Our ref: DOC22/167381-4

Your ref: SSD-6612

Martins Creek Quarry (SSD-6612) – Review of Further Information to the Response to Submissions Report

Martins Creek Quarry (SSD-6612) – Review of Further Information to the Response to Submissions Report

Figure 3: Conceptual Rehabilitation Plan

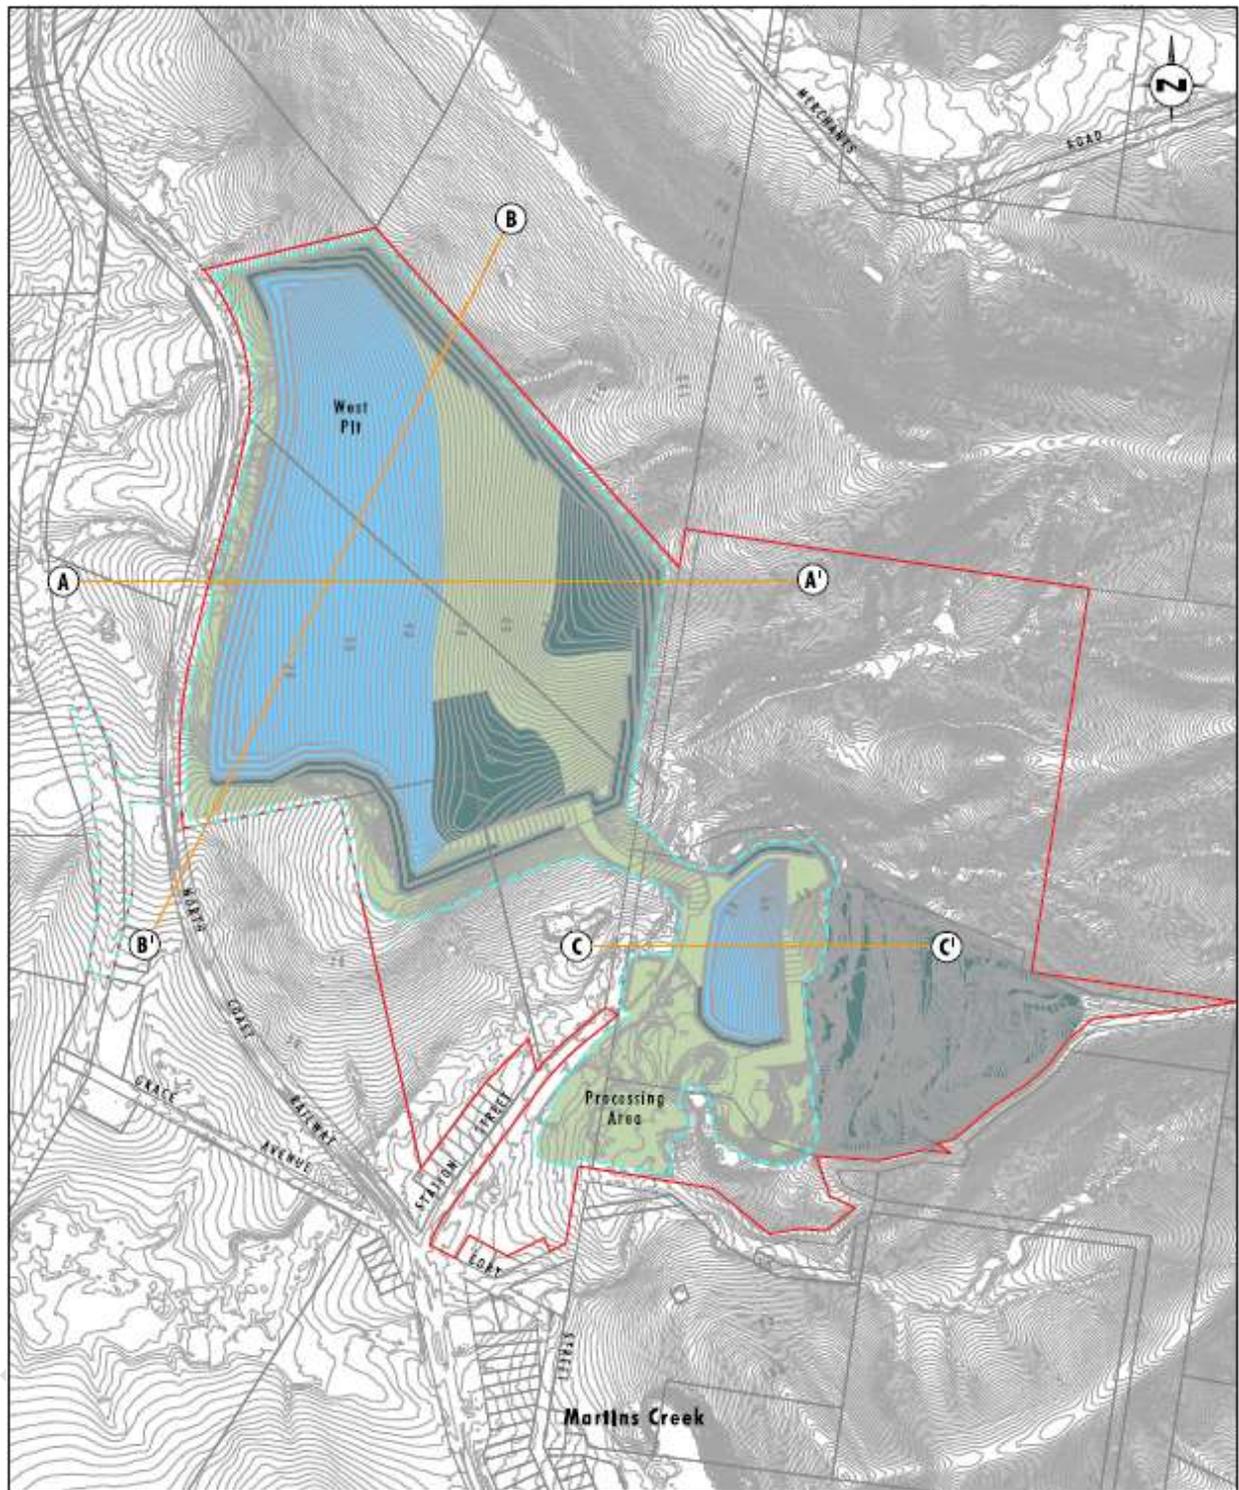
Figure 5.1 of the rehabilitation strategy indicates that two permanent voids will remain in the rehabilitated landscape. The west pit void is very large in size and the Surface Water Impacts Assessment indicates it will take approximately 22 years to fill. The smaller east pit is estimated in the report to take 8 years to fill. This means that water from within the catchment will not flow into the downstream waterway for the full duration of the time taken to fill the remaining

In addition, the manner of discharge to the downstream waterways in a flood event will also change post-rehabilitation. Once the storage fills discharge will be via weir flow to the receiving environment with unknown effect on downstream flooding and erosion. No assessment has been made on the changed hydraulic behaviour post rehabilitation.

After quarrying operations stop, mine voids would be filled by catchment runoff over an extended time frame with no effective runoff, and yet the local hydrology would be treated as a flow-through system. There is no assessment provided of the way this flow will occur or how ongoing water quality will be managed.

The hydraulic impacts of inclusion of large mine voids in the final landform on riparian health and downstream ecosystems is to be assessed prior to approval, not deferred to rehabilitation assessment. The report prepared for item 4 above may form a baseline condition report. Any EEC in the downstream riparian area is to be identified. Removal of water may have additional biodiversity impacts and further offsets may need to be negotiated to compensate for loss of vegetation post quarry rehabilitation. An action plan is to be developed to determine how riparian condition will be protected in the long-term flow removal period following rehabilitation.

Impact on downstream flooding and streambank erosion are to be assessed by suitable hydraulic modelling for the post void filling period due to the concentration of flow and changed flow regime. Assessment of likely water quality and the potential for pollutant mobilisation in the post rehabilitation flow through scenario is to be determined together with a monitoring regime to ensure commitments made are adhered to.
